DECISION DELEGATED TO HEAD OF PLANNING

Application No: H02-0700-21 **Applicant:** Kaone Ltd.

Proposal: Demolition of single storey kitchen and part boundary wall and alterations and extensions to existing house to form holiday let.

Location: 60 North Street Crowland Peterborough

EAST ELEVATION

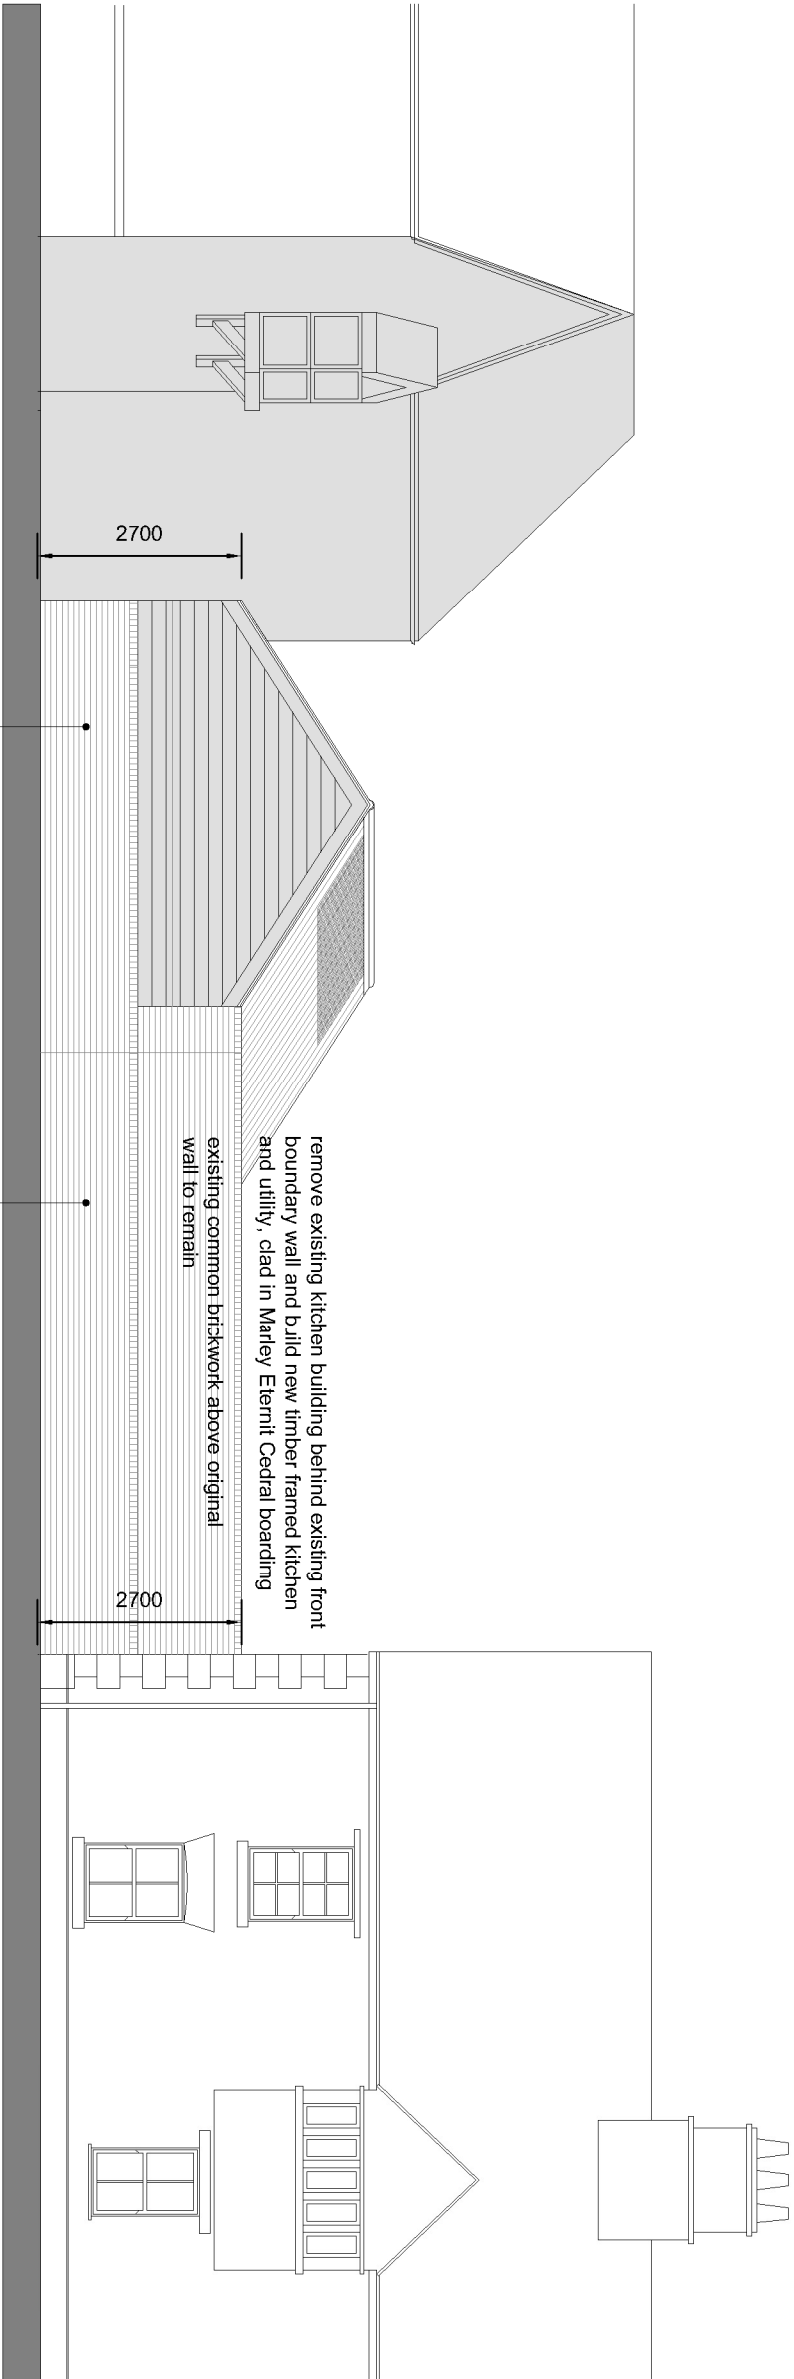
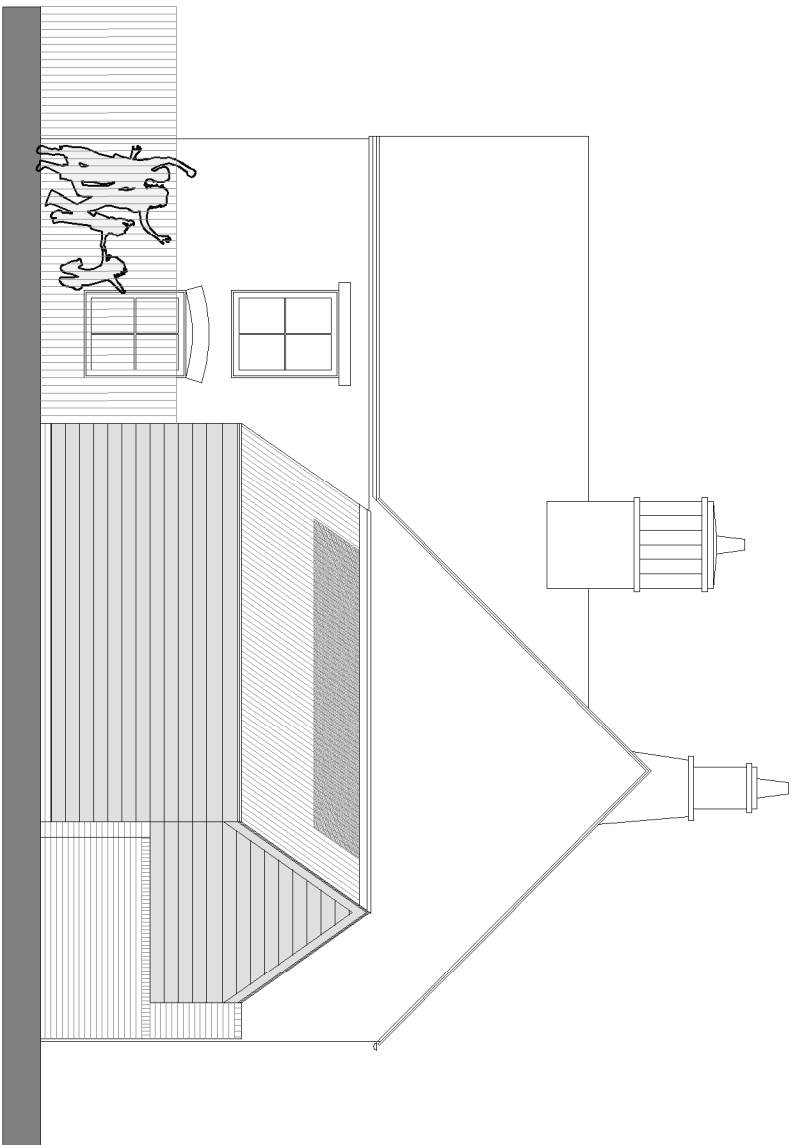
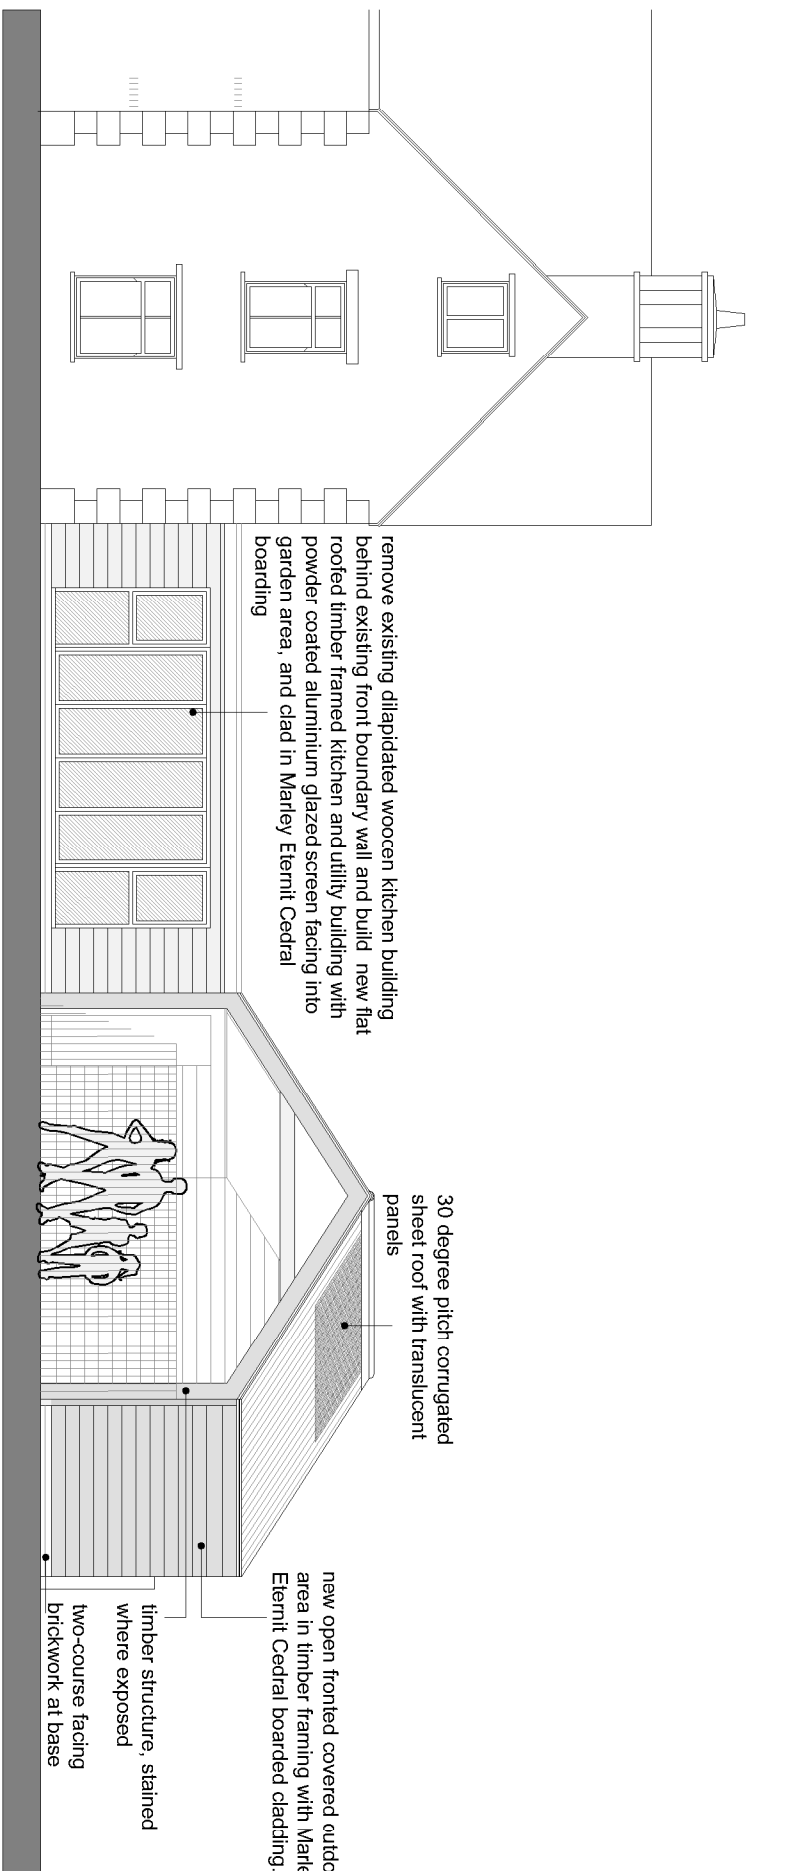
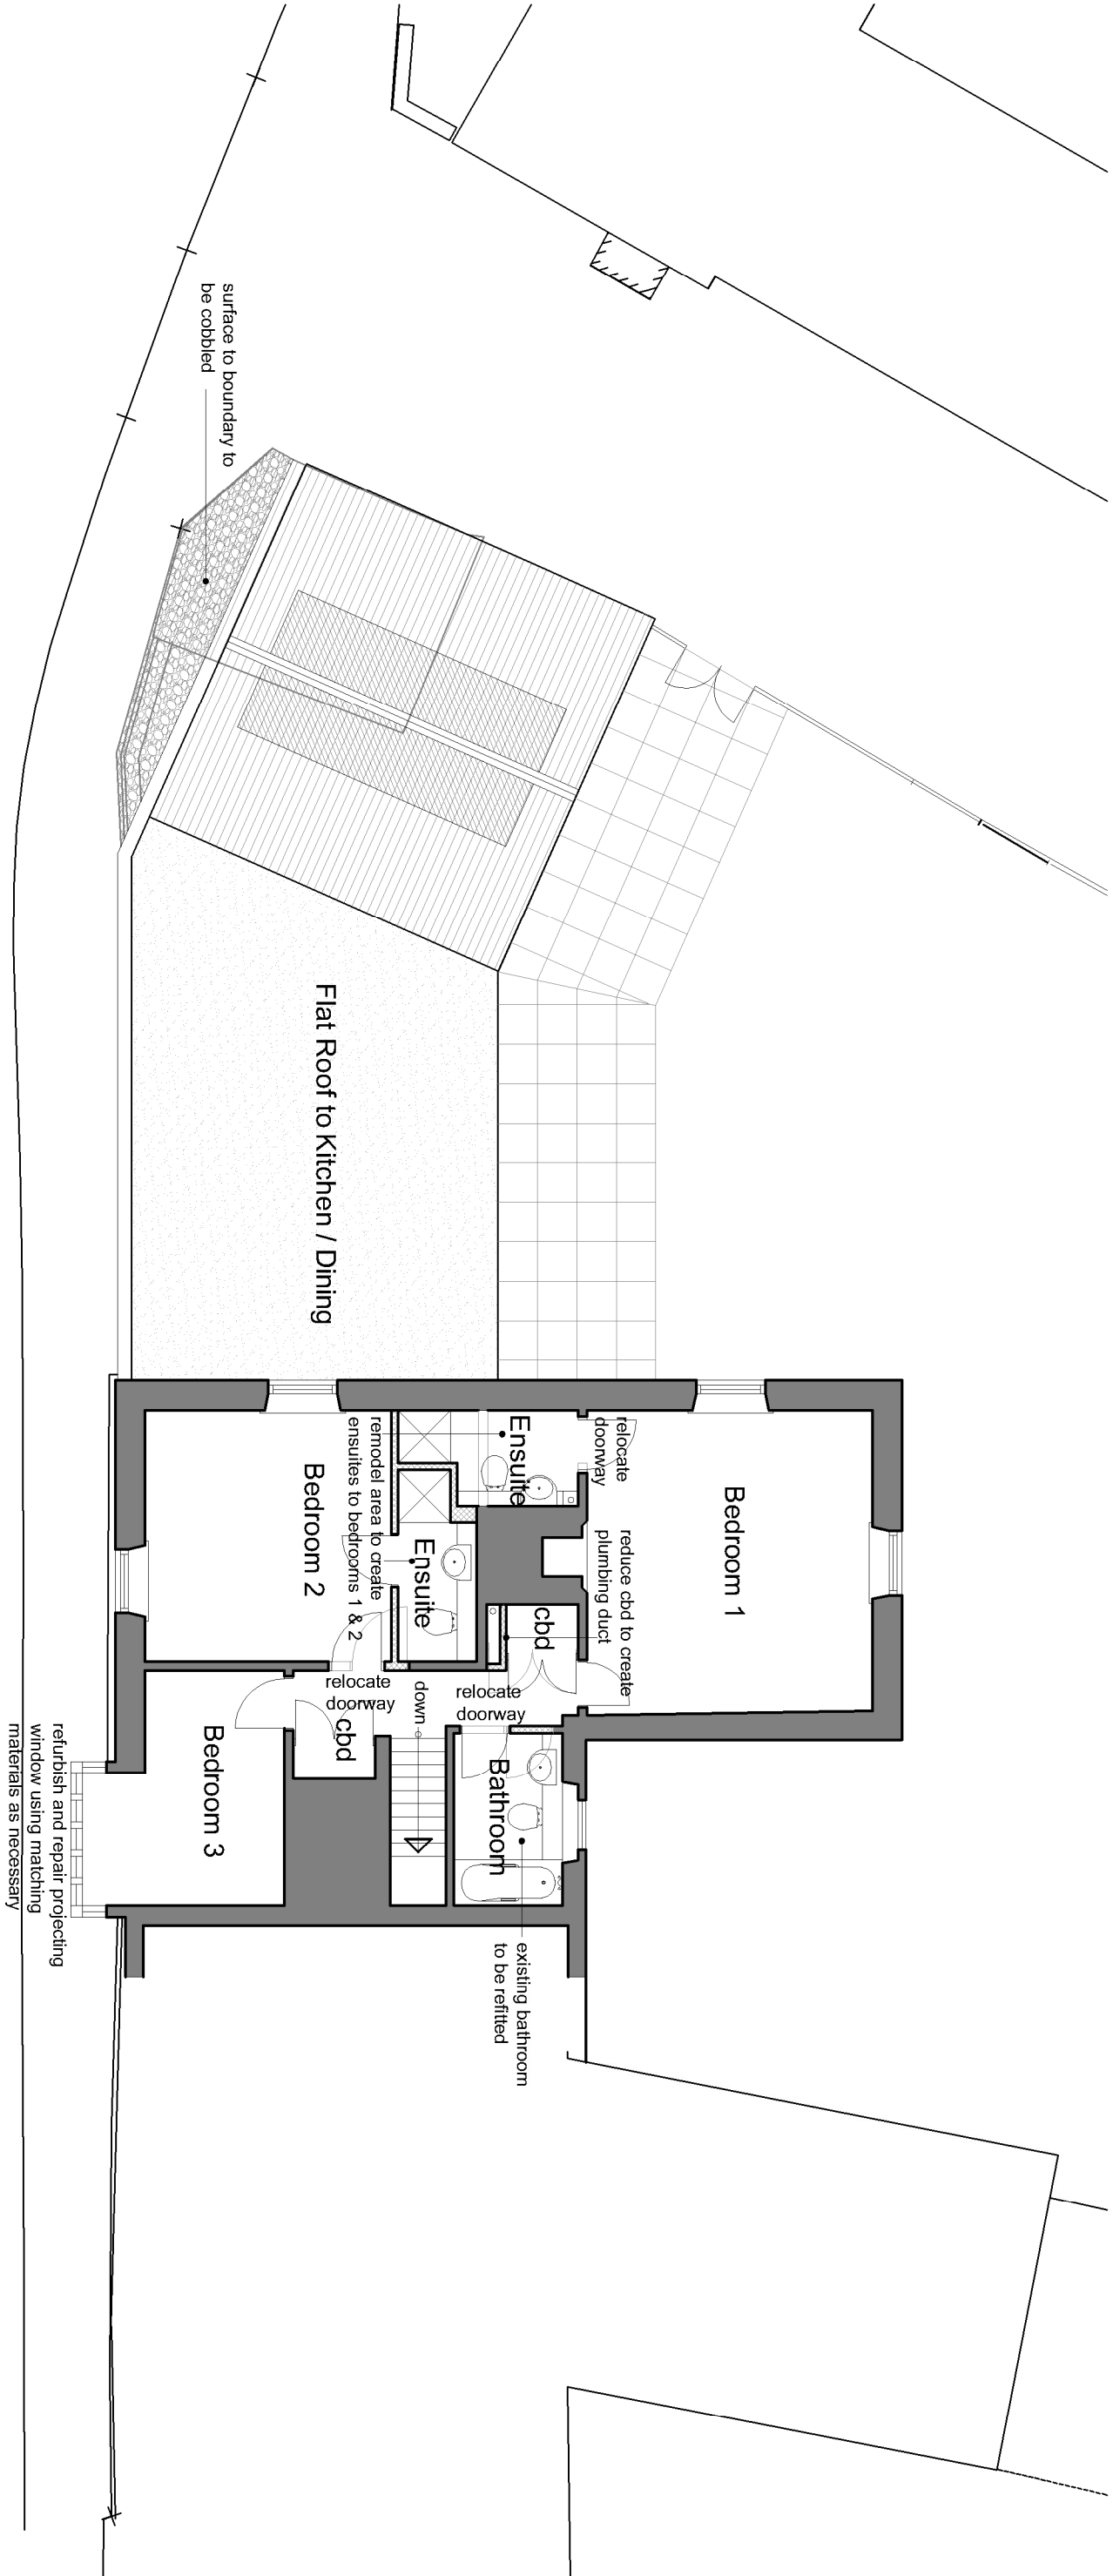
The scale and appearance of the proposed extension has been reduced from that originally submitted as concerns were raised by the Council's Conservation Officer that it was not visually appropriate to the setting, presenting what would have been a visually modern, featureless gable, with little appeal, into this portion of the Conservation Area. The pitched roof element at the southern end with cladding to the external walls has been removed and now very little of the extension would be visible from the public domain due to the existing wall to the eastern boundary and the flat roof nature of the extension. The scale is in keeping with the existing building and surrounding development. The Conservation Officer has no objection to the revised plans.

Having reviewed the updated drawings to H02-0700-21, I now find these plans to be acceptable from a Conservation Planning perspective. As the site is within the Conservation Area for Crowland, it is important that a high degree of consideration is given to the visual impact of such a proposal upon the public realm. Given that this proposal would see the public facing facade virtually unchanged, bar the restoration/reconstruction of the pre-existing wall, and because the extension design in general is diminutive in scale and modest in design to the point that it would have minimal or no impact upon the site as appreciated from the public realm; I am satisfied that this proposal helps to conserve the designated heritage asset, in line with the requirements of Section 16 of the NPPF (2021).

WEST ELEVATION

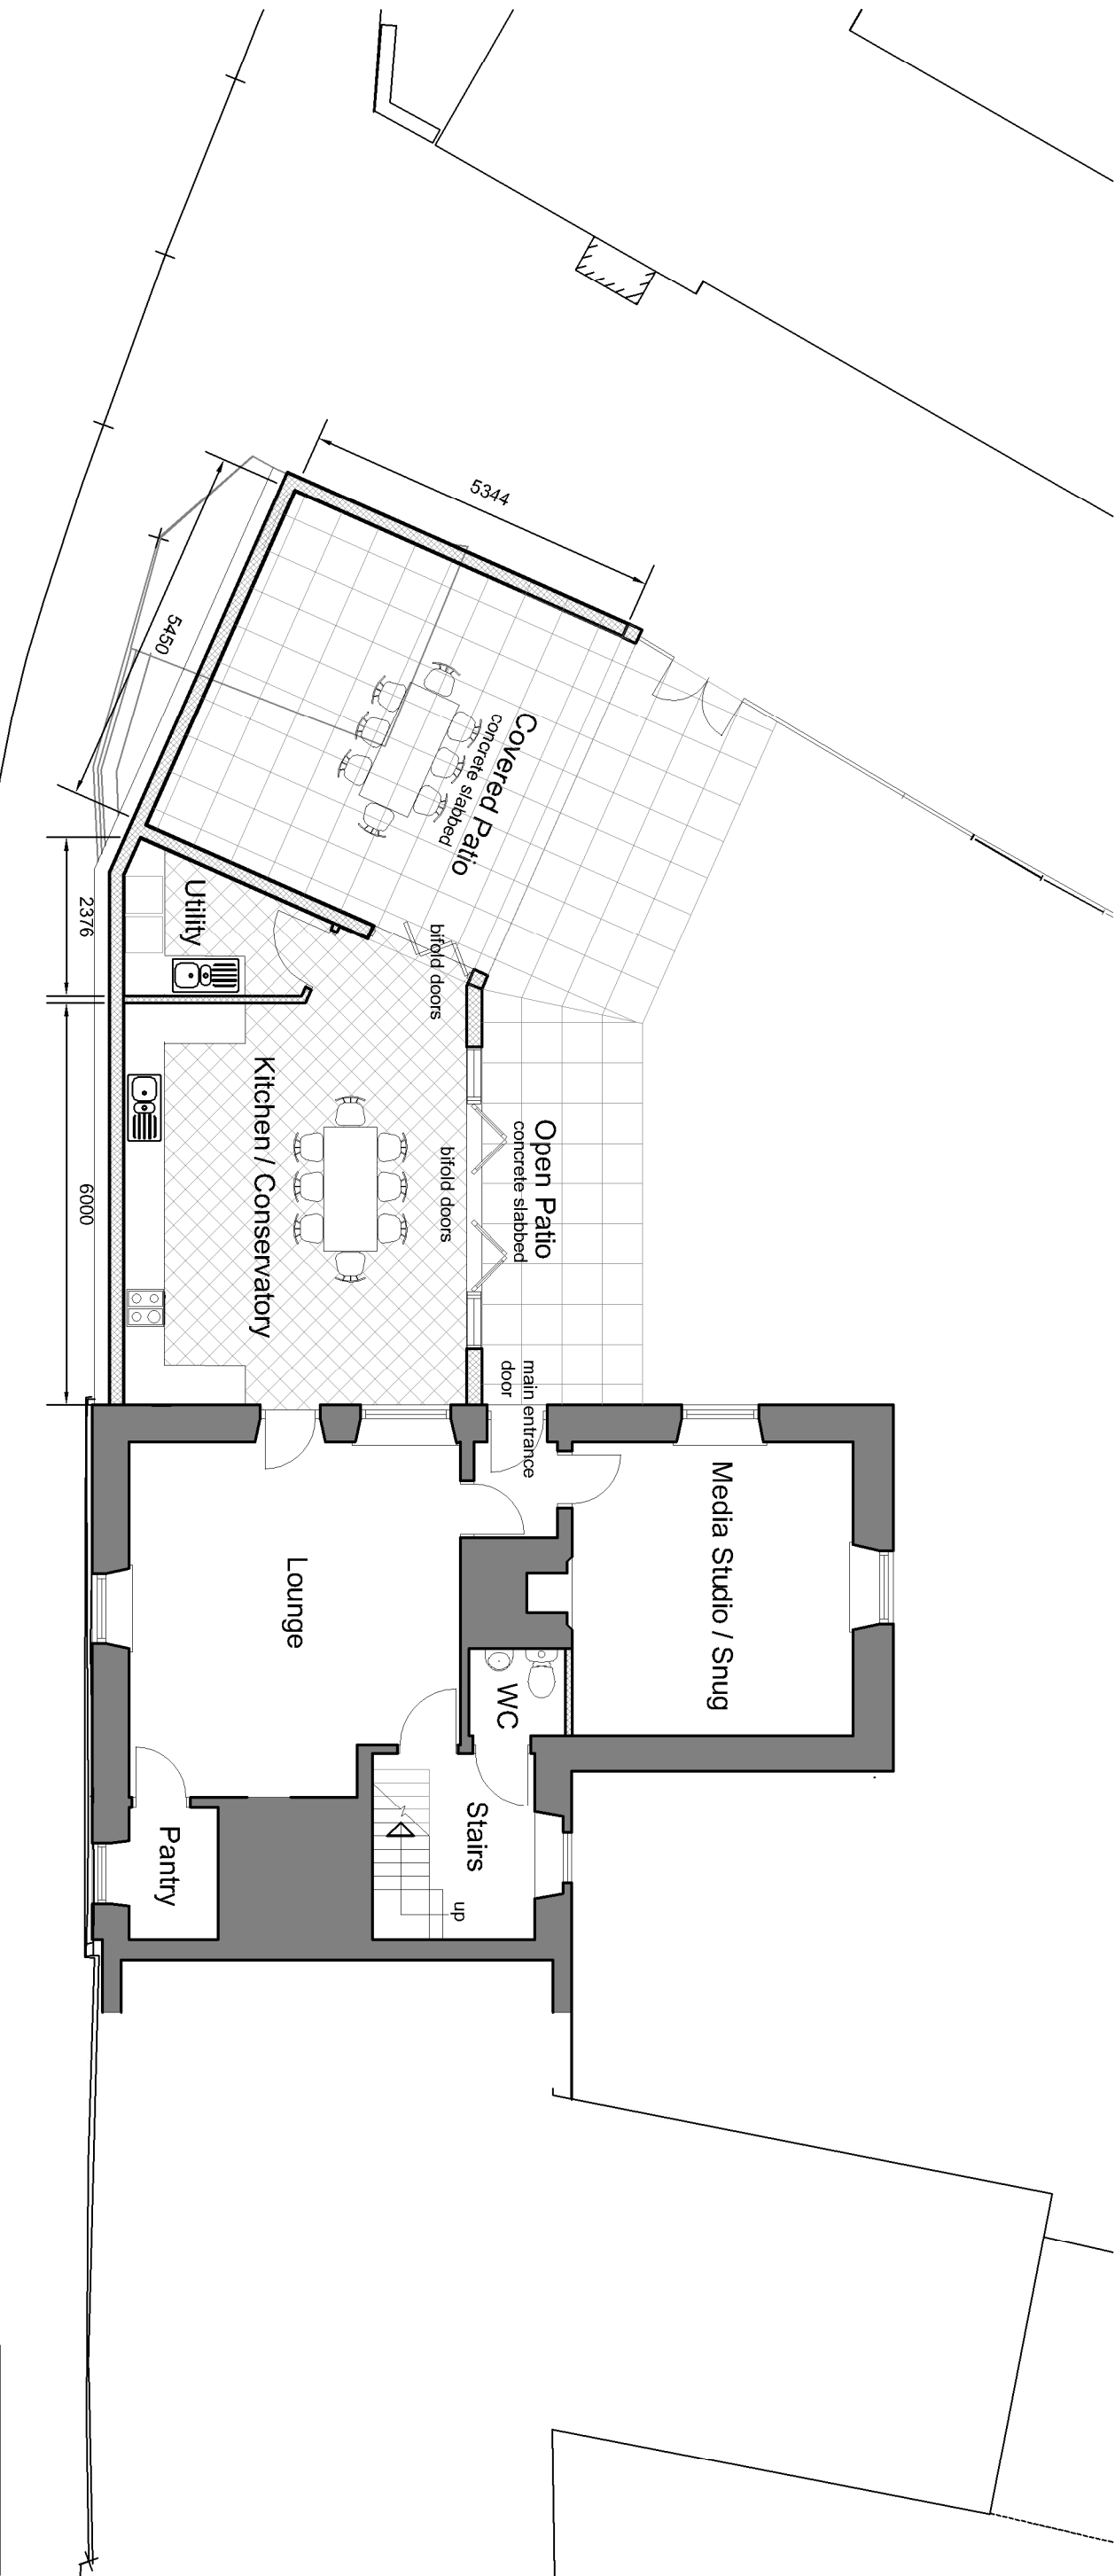
The proposed extension is single storey in scale and would be no higher than the highest part of the brick wall that currently sits at the back edge of the footway on North Street. The glazed screen to the western elevation will face towards the garden of the building, which is some 17m in length beyond that elevation. There is an extant planning permission for 10 new dwellings to the rear (H02-1765-06), but these are set at an angle from the proposed extension and beyond 21m, which is usually considered an adequate distance to prevent material overlooking.
